## PLANNING CONSULTATION RESPONSE

| <b>Application No</b>             | 2026/0572                                                                                                                               |
| <b>Proposal</b>                   | Refurbishment and resurfacing of a carpark, installation of a 2.4m high fence to form contractors compound and creation of rain garden. |
| <b>Consultee</b>                  | Highways DC                                                                                                                             |

Drawing: Proposed Site Plan- Car Park

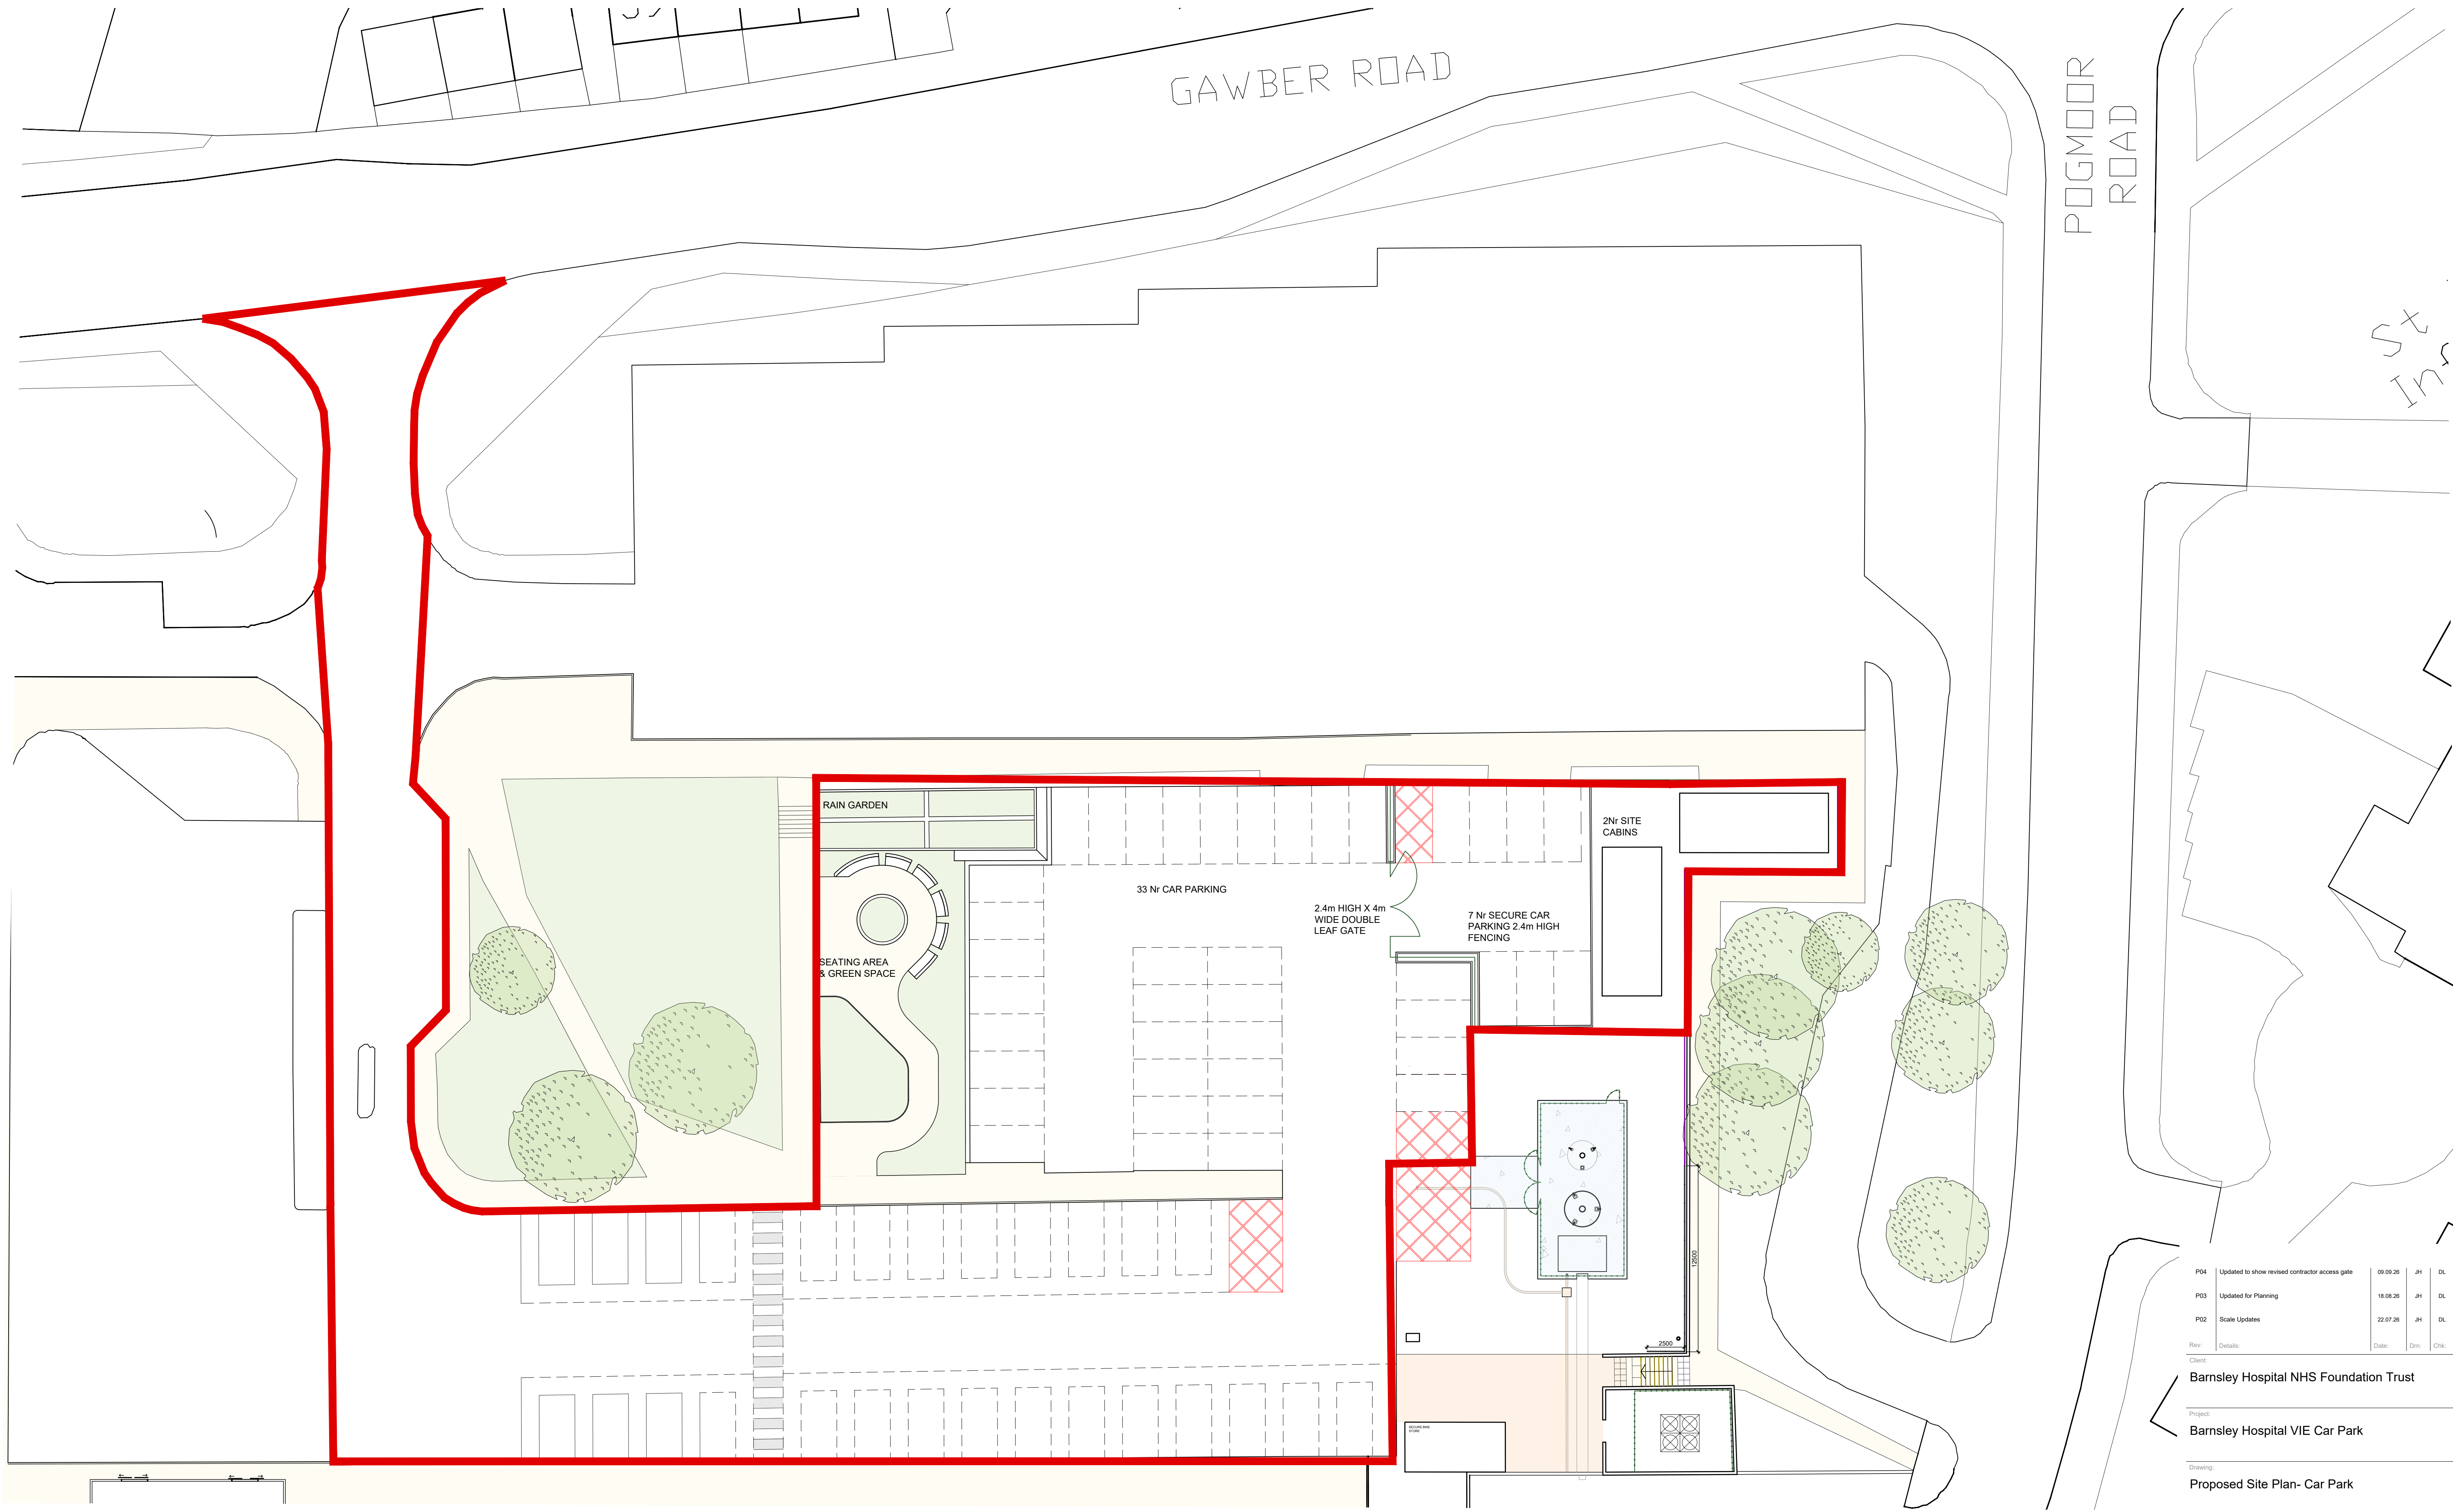
The proposed layout includes parking spaces of sufficient dimensions and 6m+ aisle widths. Swept path manoeuvres demonstrate that the layout can accommodate the manoeuvres of both a car and a small van. It is proposed for vehicular areas to have permeable surfacing.

Prior to the development being brought into use, all areas to be used by vehicles shall be laid out in accordance with the approved plan and must be properly consolidated and drained into the site and subsequently maintained in good working order at all times thereafter for the lifetime of the development.
